# Responses to Comments

TOTAL SHEETS

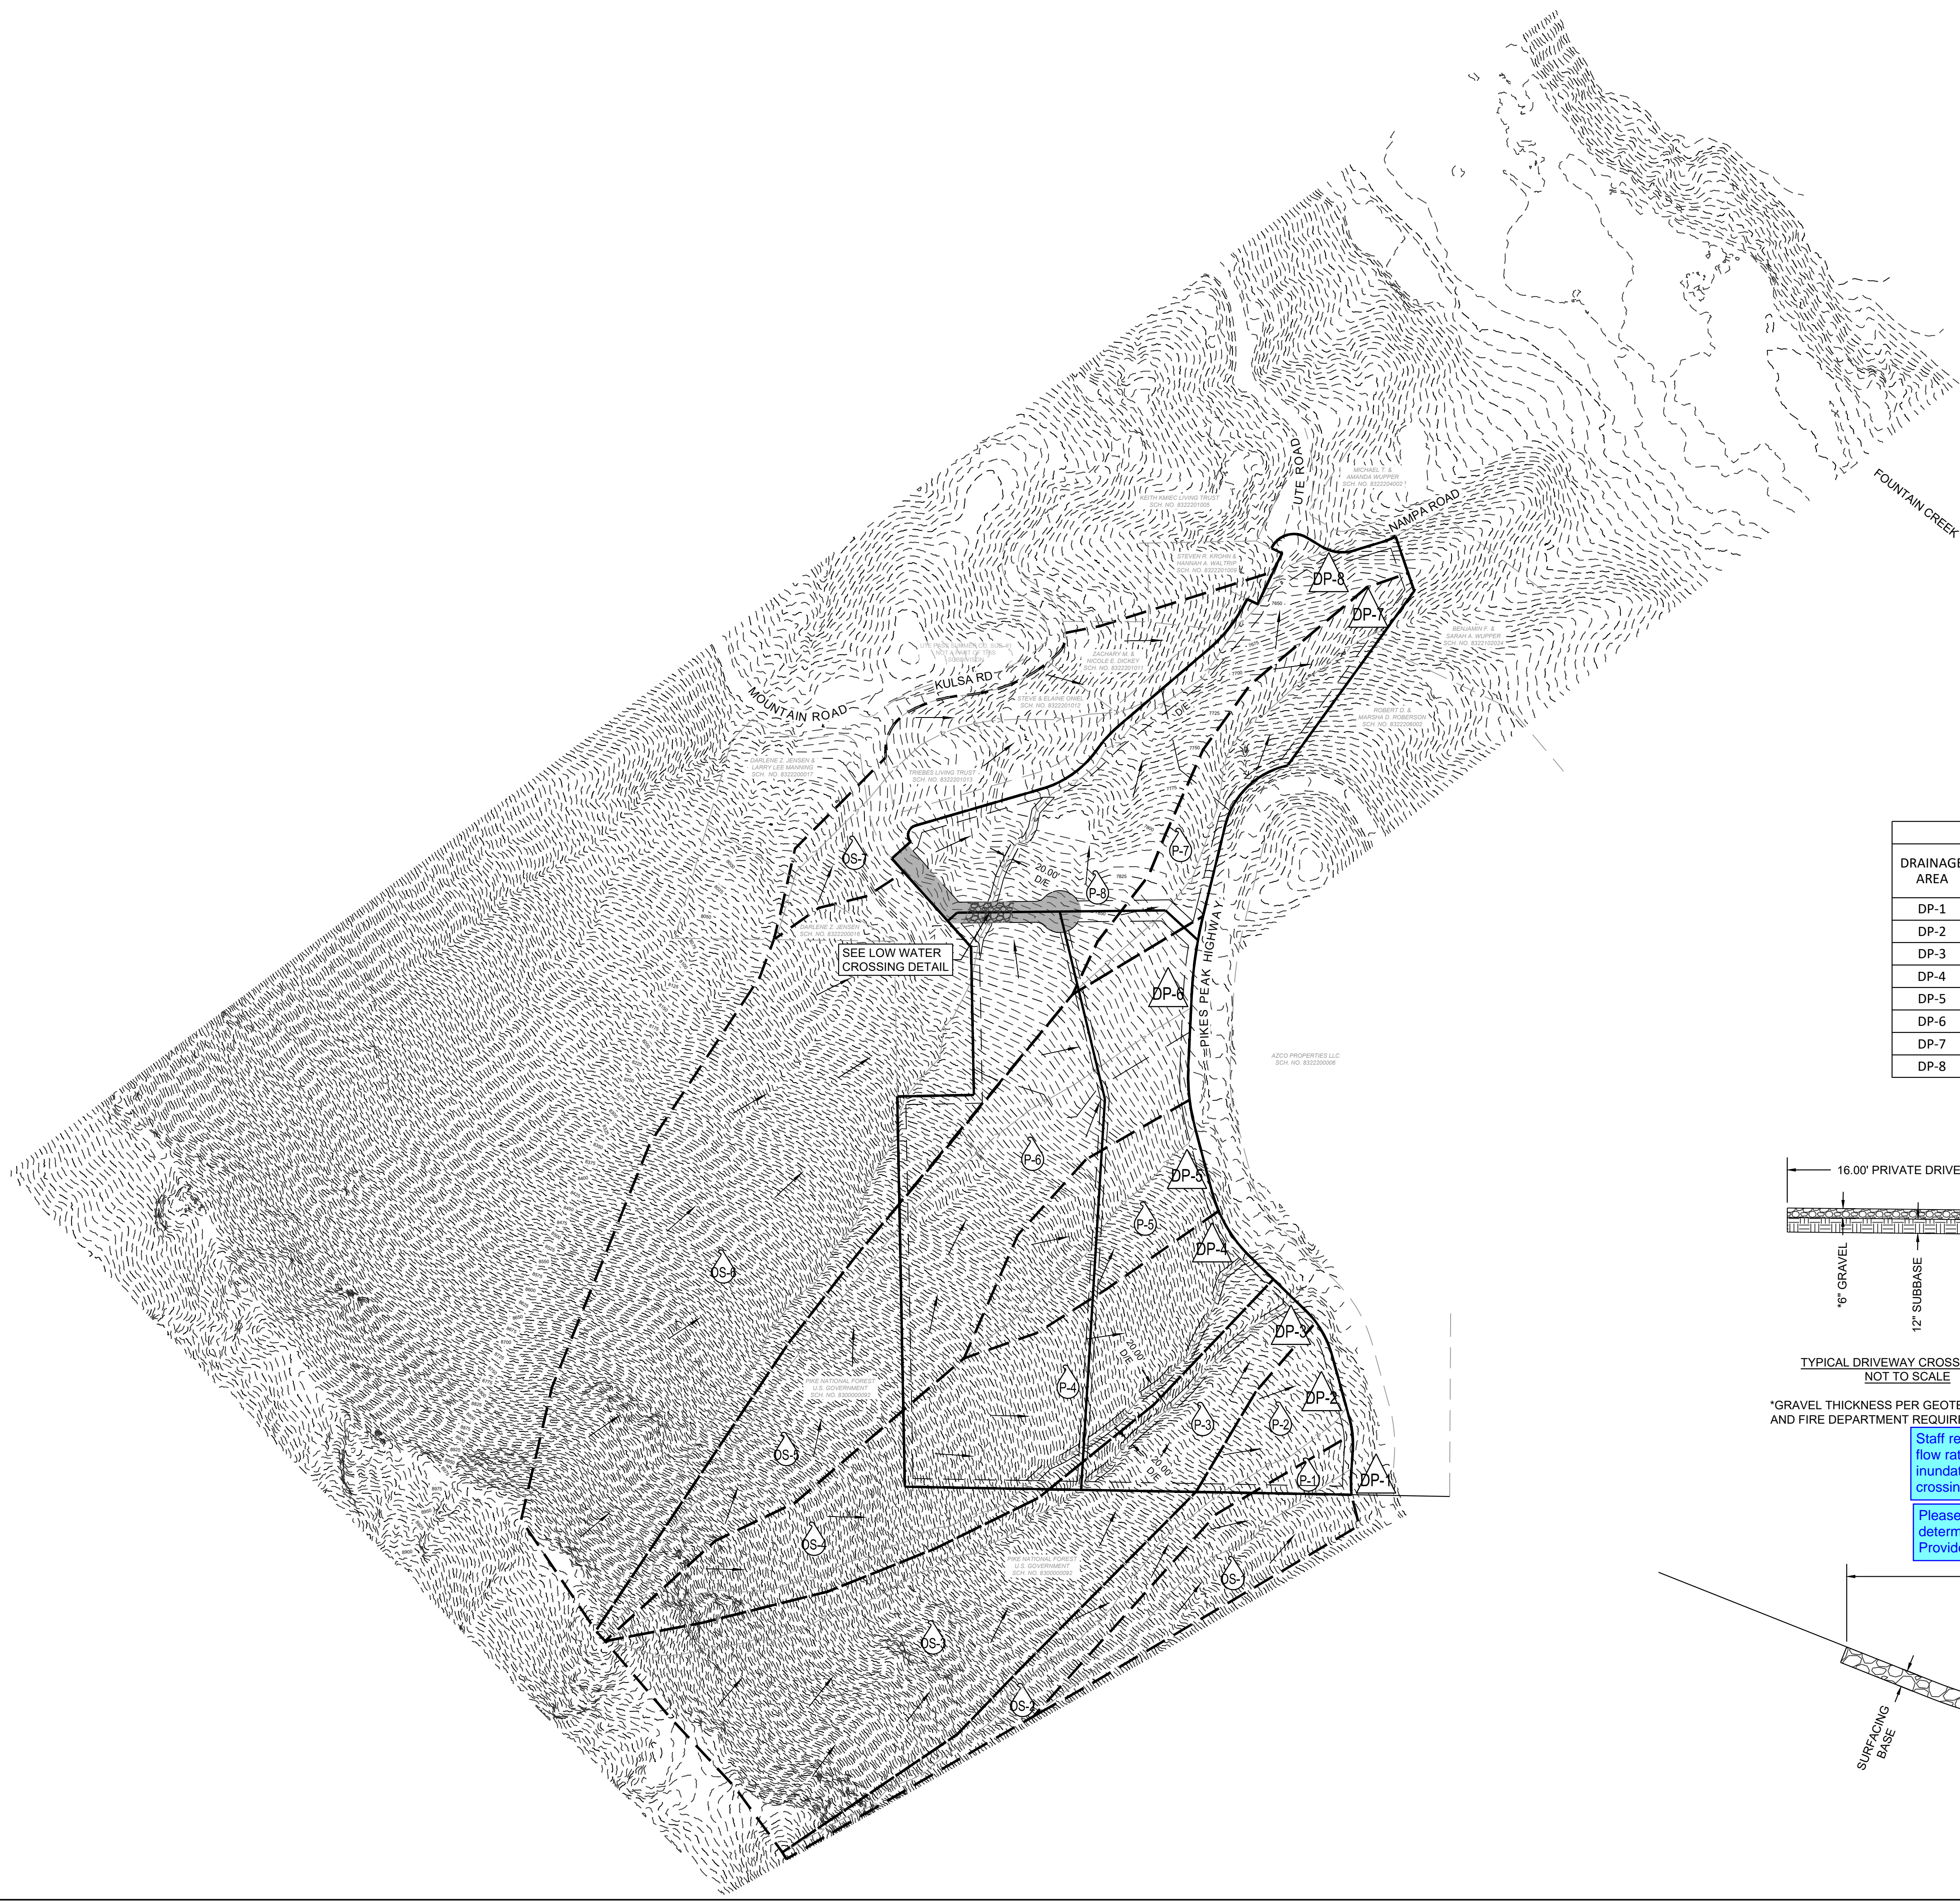
**Noted.**
  - If SIA is no longer needed, I recommend it be removed from the file to avoid confusion.  
**Noted.**
- **Drainage Report:**
  - Staff recommends culverts be used due to the high flow rate, erosion of gravel driveway, and possible inundation of driveway from flows overtopping water crossing.

**Culvert has been added.**
  - Please provide calculations for the low-water crossing to determine the ponding depth and width of the crossing. Provide calculations for the minor and major storms.

**??**
- **Colorado Division of Water Resources:**
